**Consultation Response from KC,
Highways Development Management****2025/90413 Land adjacent, 40, Manchester Road, Slaithwaite, Huddersfield, HD7 5JA****Demolition of existing garages and erection of two dwellings and associated works****Date Responded: 21-5-2025.****Responding Officer: Mark Berry.****Responding Ref: 1-32-4.**

This application seeks approval to the demolition of existing garages and erection of two dwellings and associated works at Land adjacent, 40, Manchester Road, Slaithwaite, Huddersfield.

Proposed lower ground
floor layout (1:100).
(26.58m²/285.7ft² floor area)

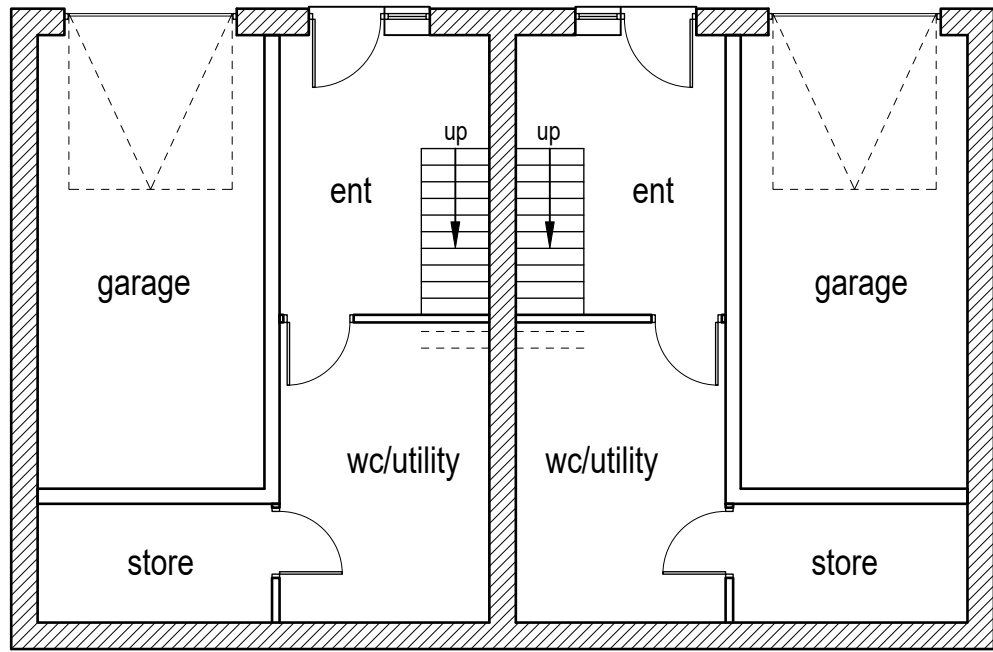
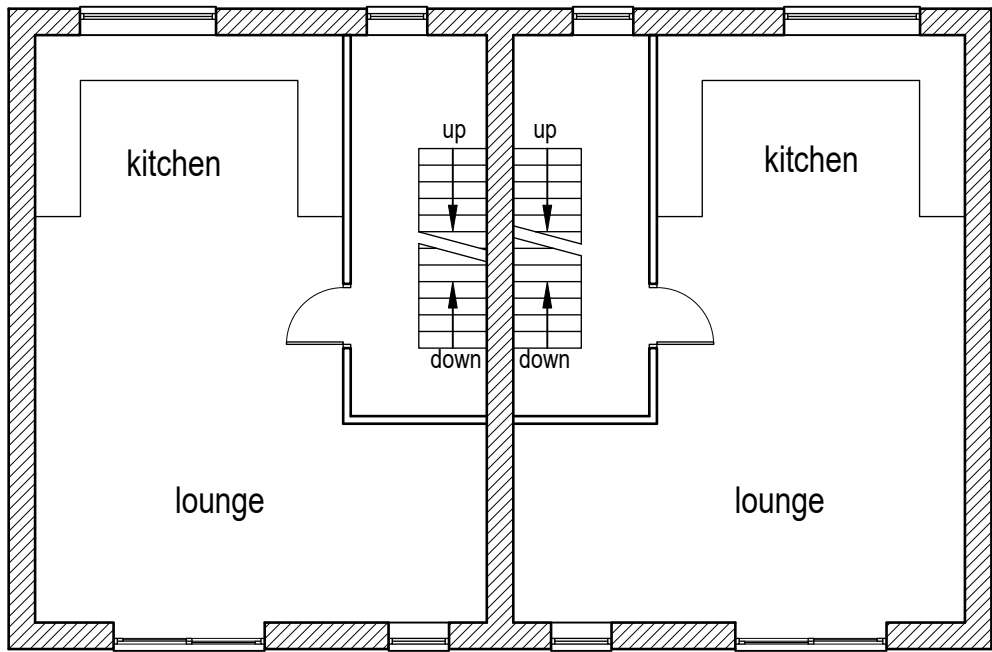
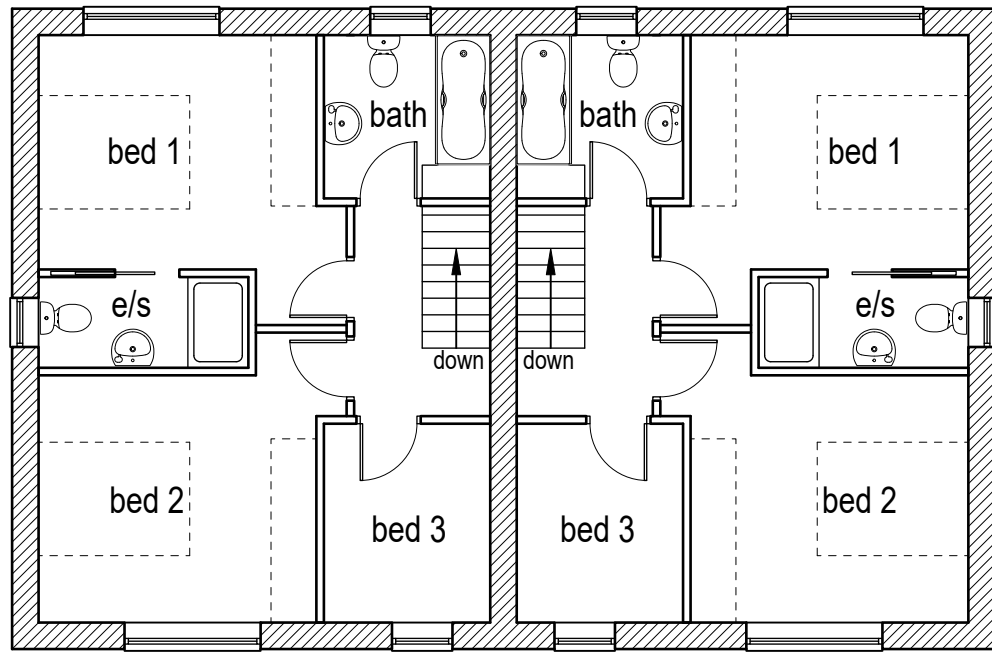
3, The dimensions of the proposed garage need to be confirmed. 6.0m x 3.0m is the minimum standard acceptable.

Proposed block plan (1:500).

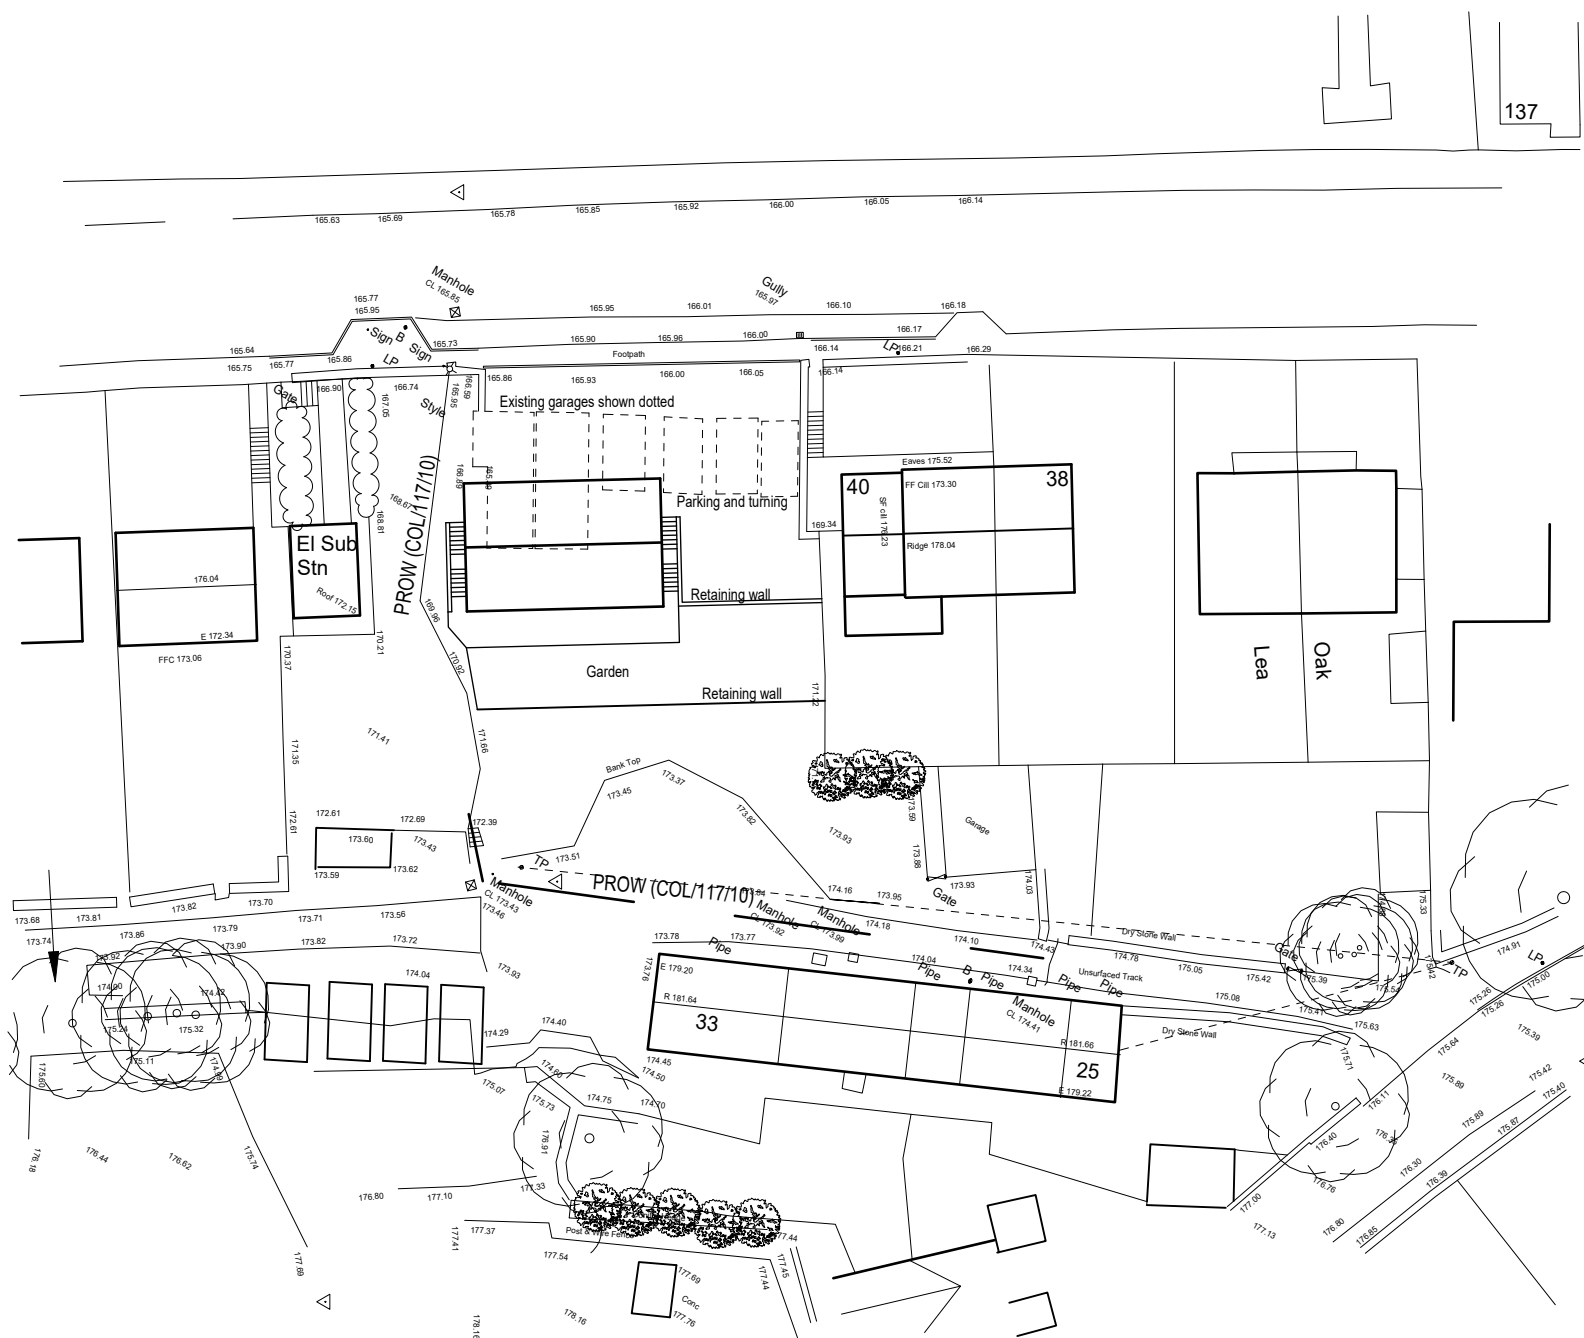
1, The proposed dwellings are shown to be located on the western side of the site against the boundary with the PROW and close to the Bus Stop. This means access to the western plot will be obstructed by a bus standing at the stop. There will also be conflict with pedestrians standing waiting for a bus and users of the PROW. HDM would recommend that the dwellings are re-sited to the opposite side of the site.

2, The plans don't clearly show the proposed driveways to the frontage of the garages. The driveways should be clearly shown and dimensioned. The point of access for the PROW onto the back of footway along Manchester Road should also be clearly shown to demonstrate that access is not compromised.

4, Bin collection points should be shown to be provided to both dwellings to enable bins to be presented on collection day without either obstructing the highway or proposed driveways.
